From: Mundy, Ben - Oxfordshire County Council <Ben.Mundy@Oxfordshire.gov.uk>
Sent: 13 November 2023 14:57
To: DC Support; Rebekah Morgan
Cc: Transport CDC Minor; Cllr Ian Corkin
Subject: 23/02847/F College Farm, Main Street, Wendlebury, Bicester, OX25 2PR

Planning Application: 23/02847/F

Location: College Farm, Main Street, Wendlebury, Bicester, OX25 2PR

Description: The construction and siting of 2 no. self-catering holiday let straw bale cabins, associated Change of Use and associated works including access track, decking and a sewage treatment plant

SITE PLAN 1:100

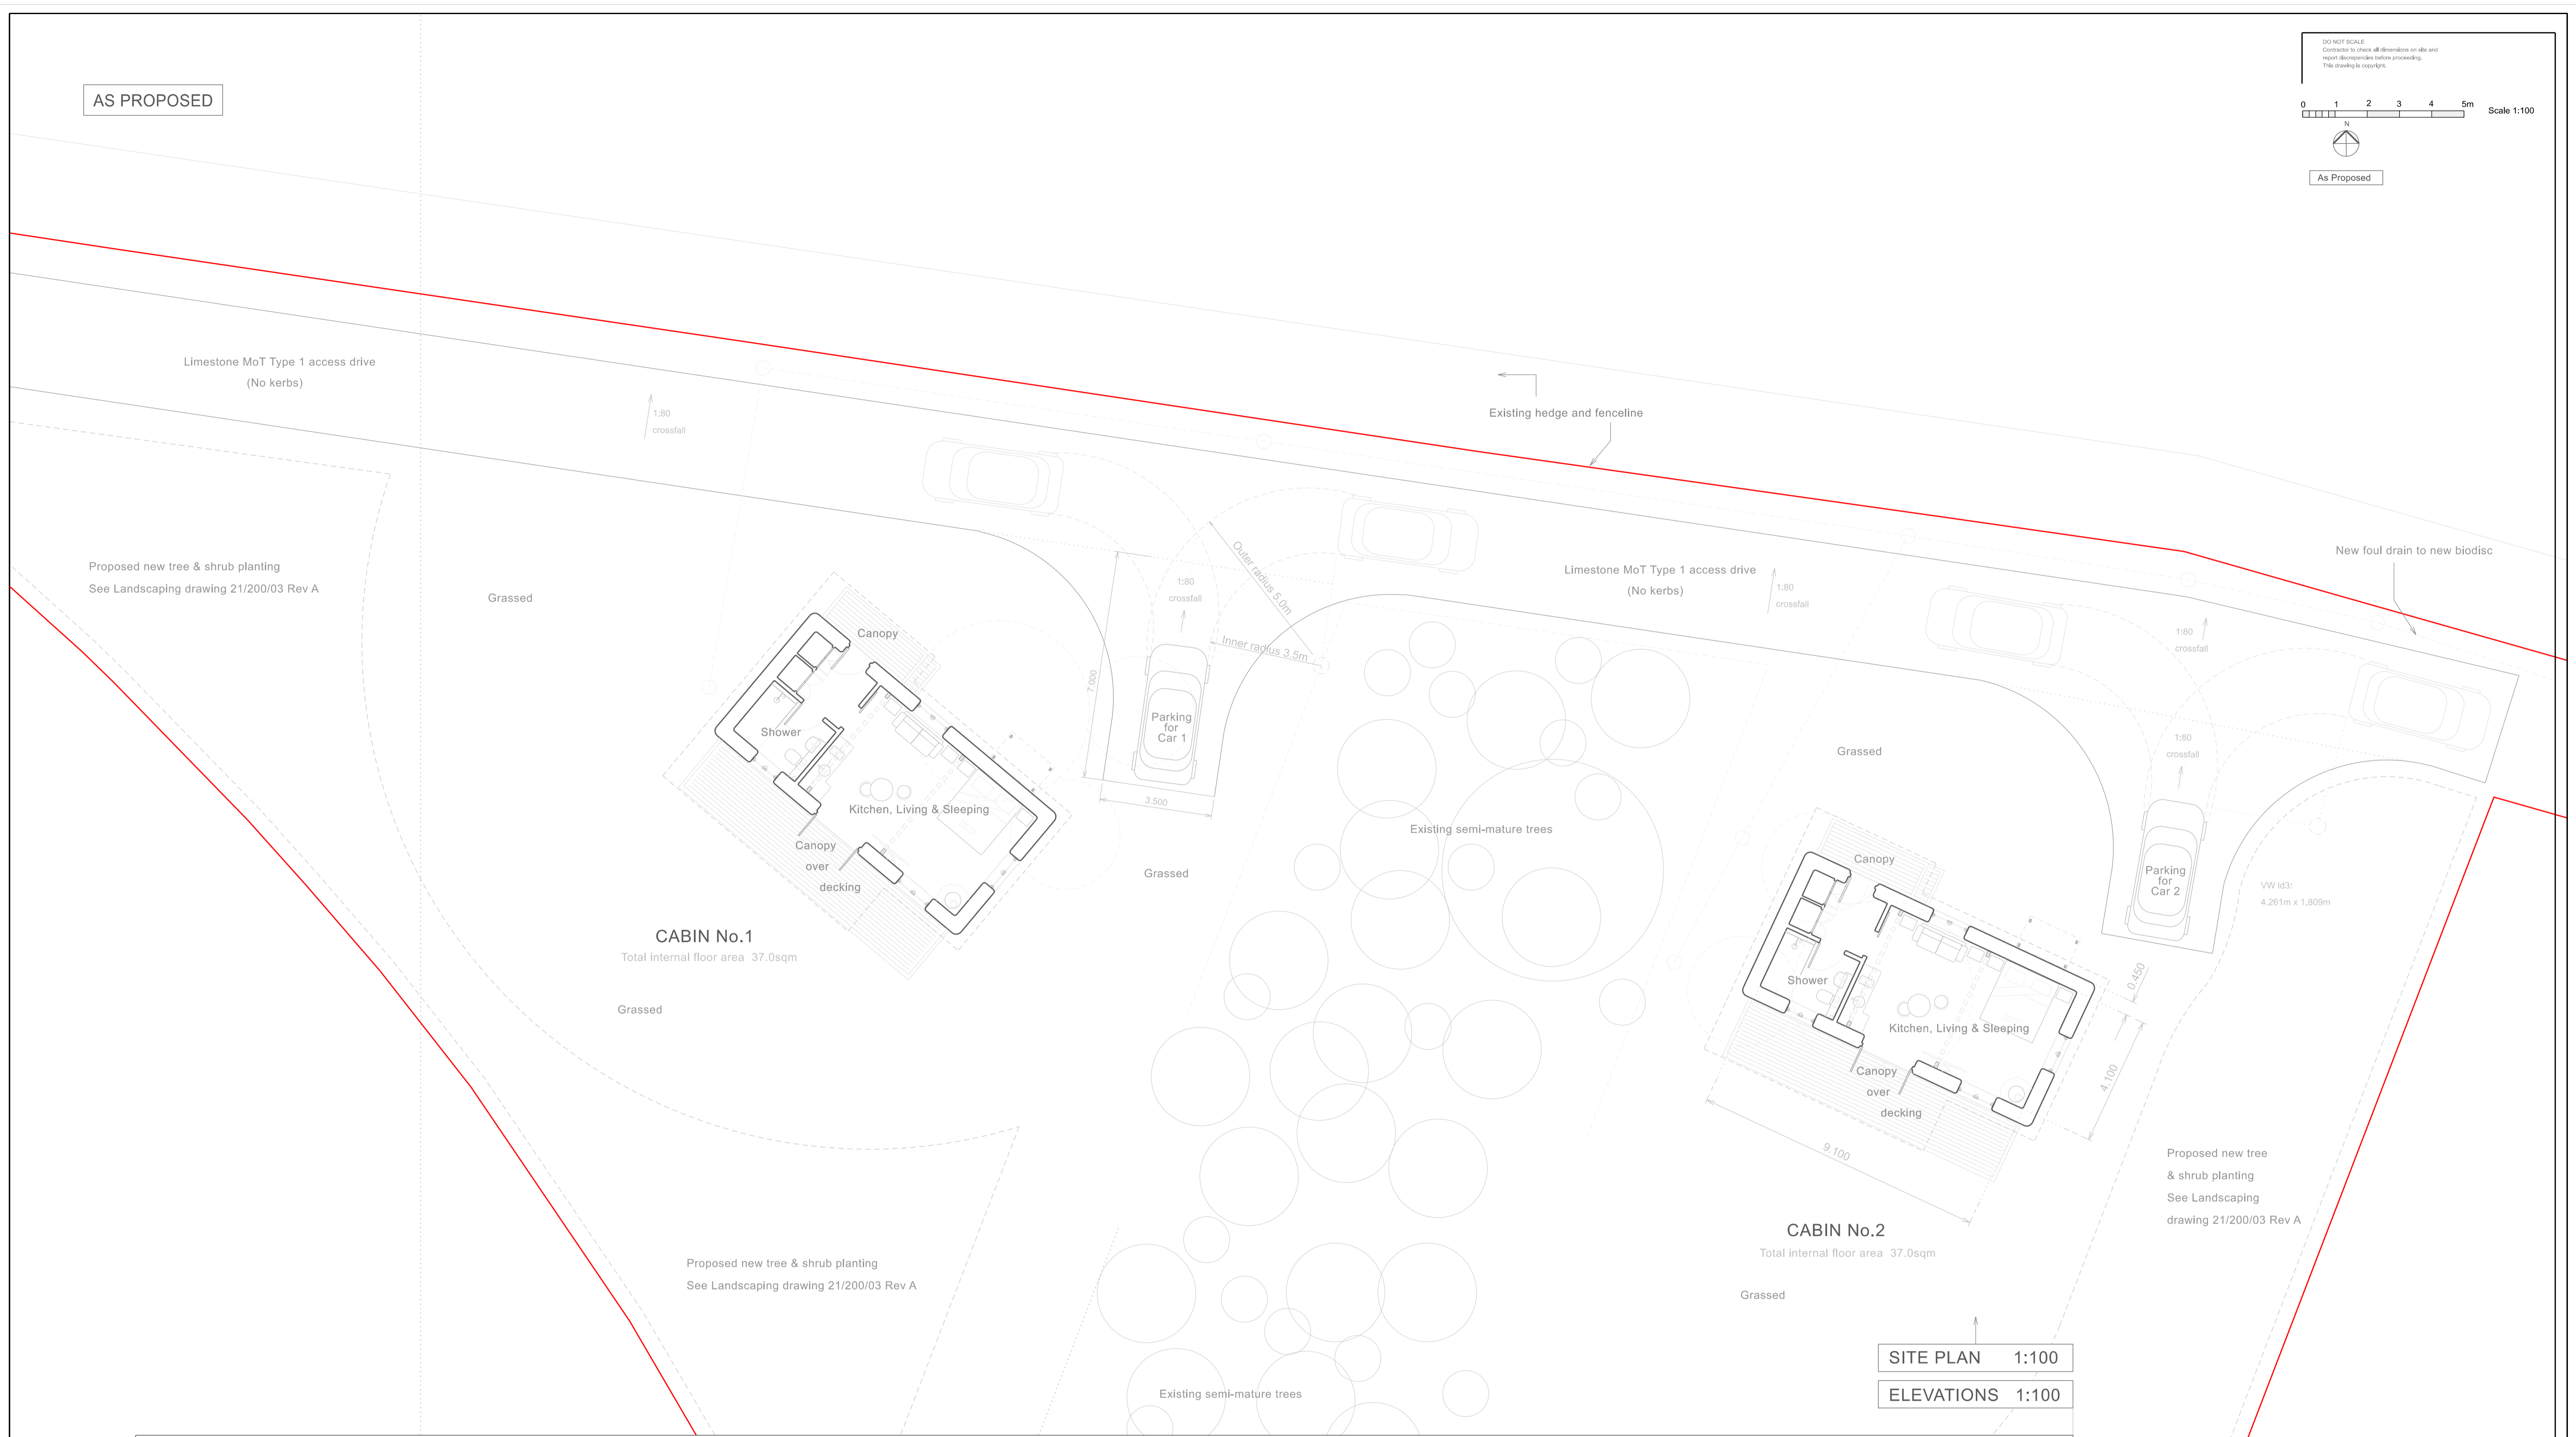
The applicant must demonstrate that the parking area can accommodate a space measuring 2.5m x 5.0m and incorporate the required manoeuvrability. The current layout has the vehicle space slightly overhanging the access road.

Prior to the commencement of the development hereby approved, a plan showing a car parking provision for 2 spaces to be accommodated within the site to include layout, surface details, and drainage, shall be submitted to and approved in writing by the Local Planning Authority. Thereafter, and prior to the first occupation of the development, the parking spaces shall be laid out, surfaced, drained and completed in accordance with the approved details and shall be retained for the parking of vehicles at all times thereafter.
